From: Amanda Scholes on behalf of Planning.Responses
Sent: 17 November 2020 11:02
To: Planning Scanning
Subject: FW: Land at Stakers Farm, Yapton - Y/71/20/RES & Y/72/20/RES
Attachments: 19-156-05 Drainage Technical Note.pdf

Project Name : Stakers Farm, Yapton

Note Title : Technical Note

1.1.1 We have been instructed by Dandara to provide a short statement to alleviate the concerns of Arun DC relating to the drainage design by explaining the design principals and very difficult constraints of this site.

**INFILTRATION BLANKET
(GEOCELLULAR UNITS - CRATES - CONSTRUCTION)**

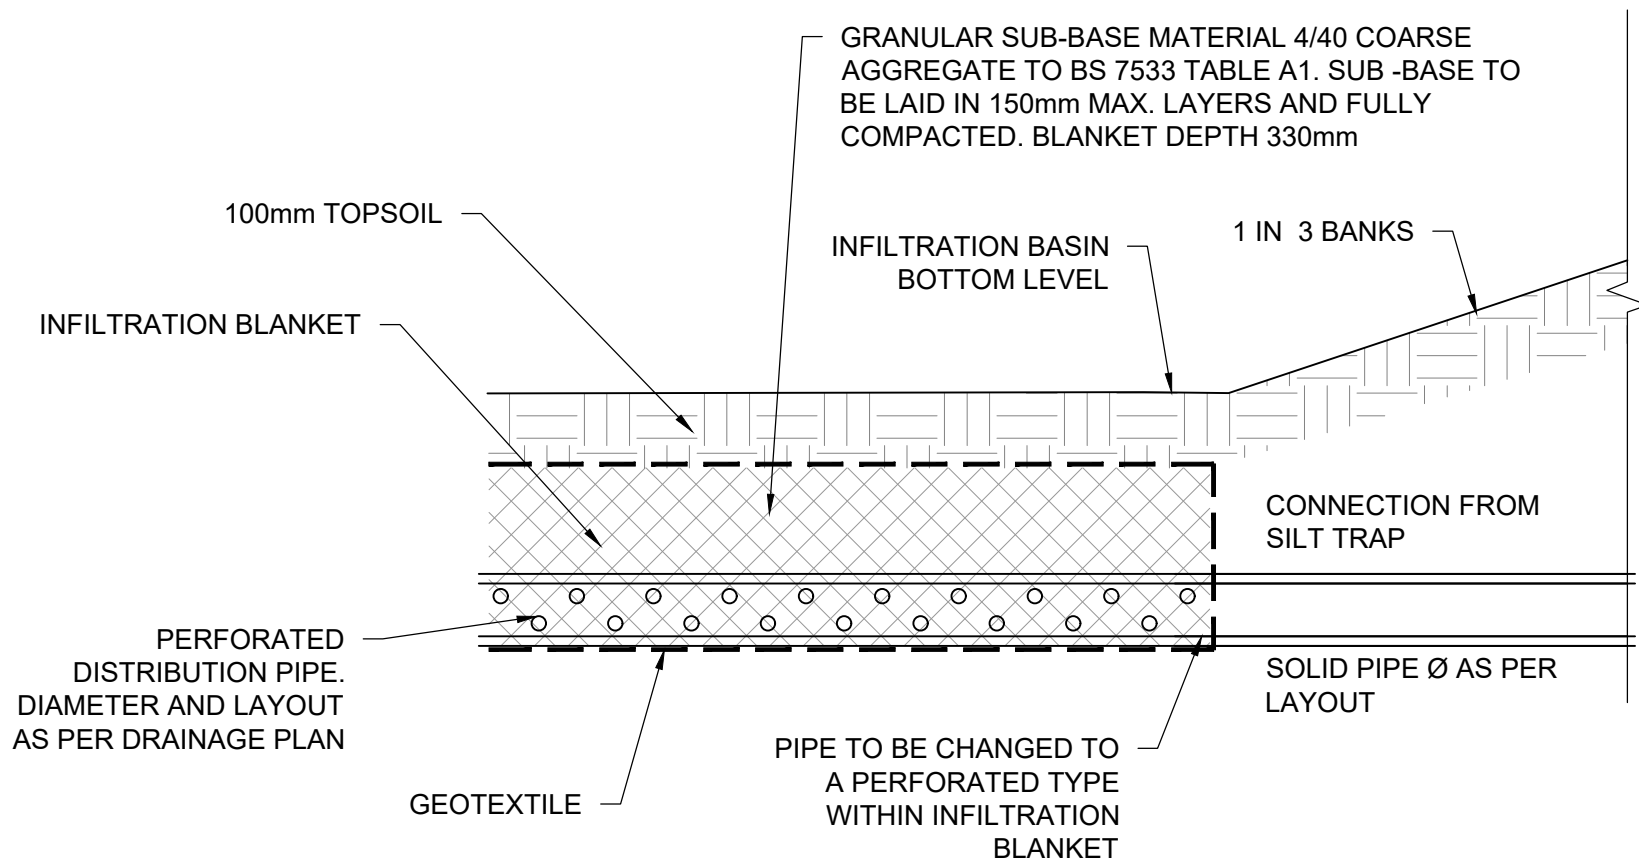
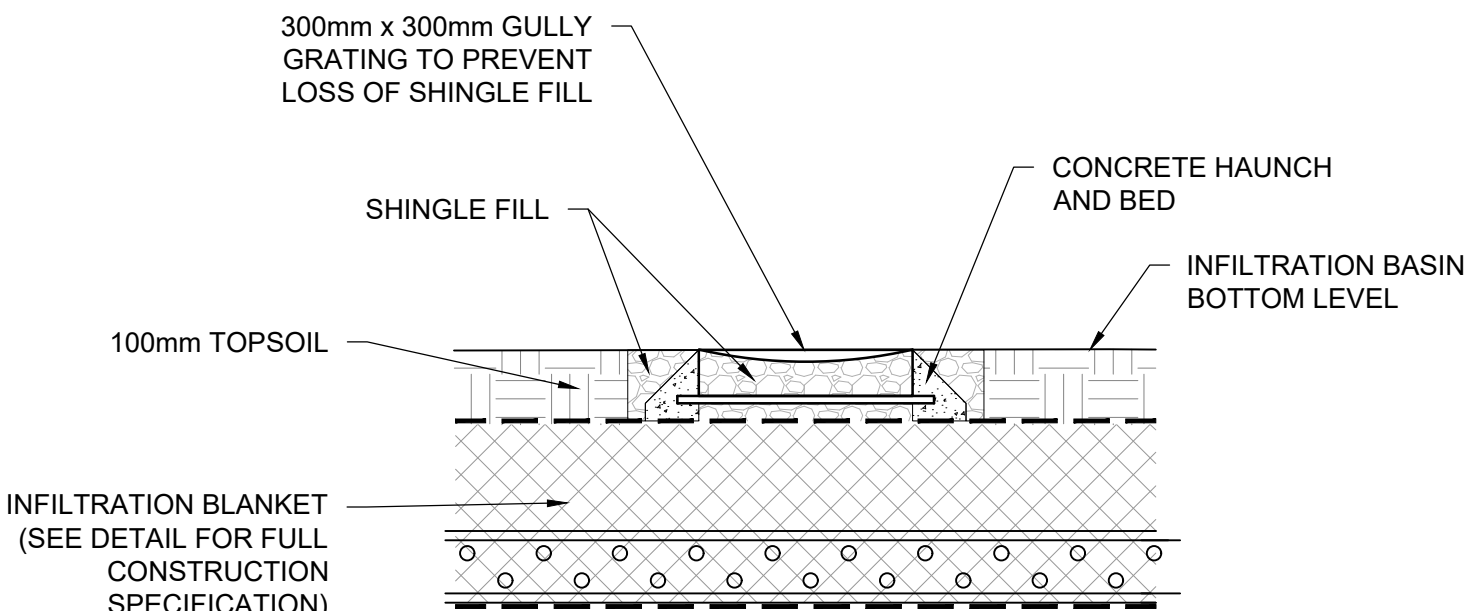
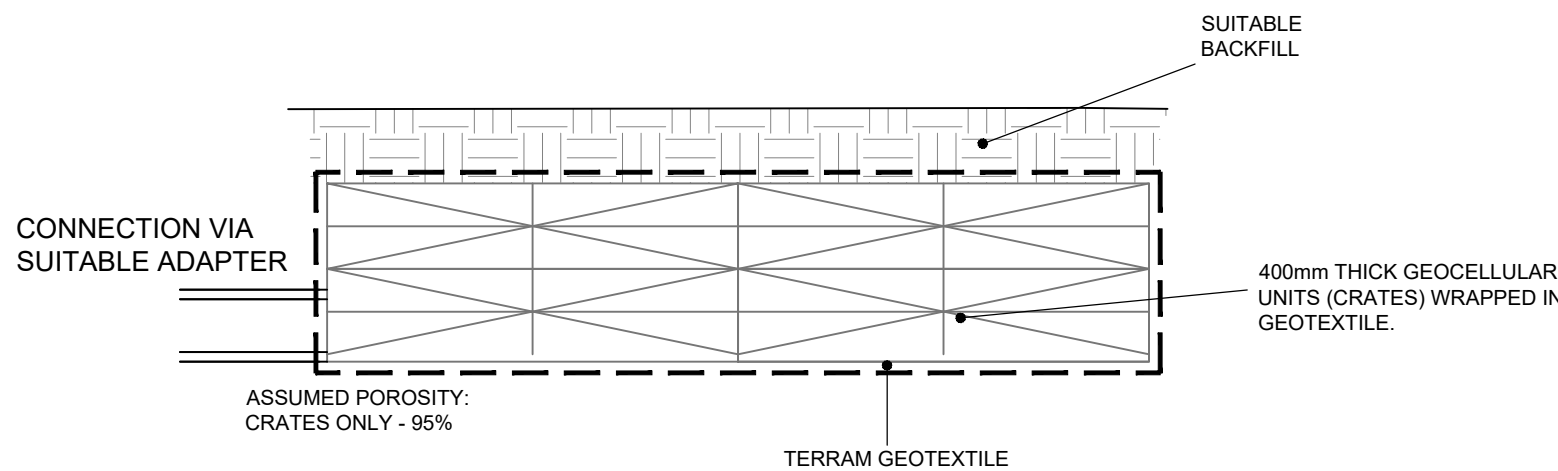
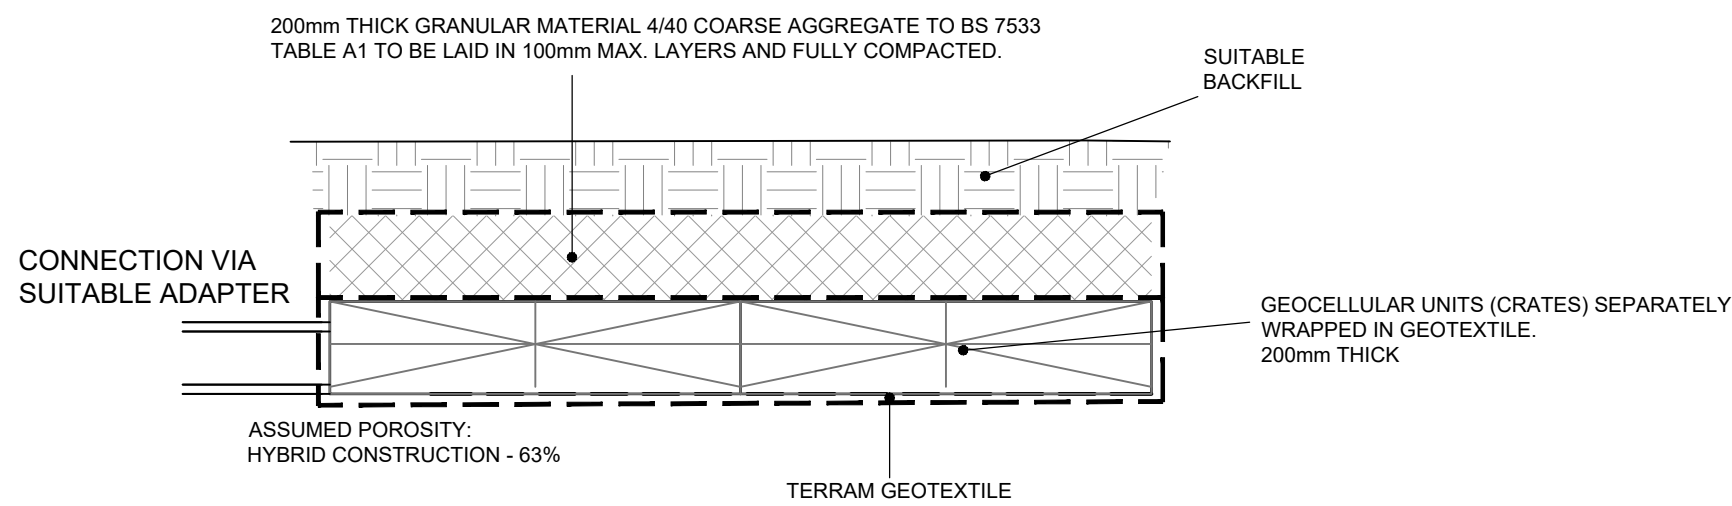
4.1.3 Arun DC Drainage engineer comment – “All SuDS features must be located outside of the utilisable open space. The LAP must not be within the basin” (comment relevant to the 38 units scheme)

4.1.4 Arun DC Drainage engineer comment – “Adequate freeboard must be provided on open SuDS features” (comment relevant to the 38 units scheme)

Odyssey response – Design is amended to use only sub-surface geocellular units infiltration storage with no surface basin. ADC comment not relevant any longer

Odyssey response – Design is amended to use only sub-surface geocellular units infiltration storage with no surface basin. ADC comment not relevant any longer
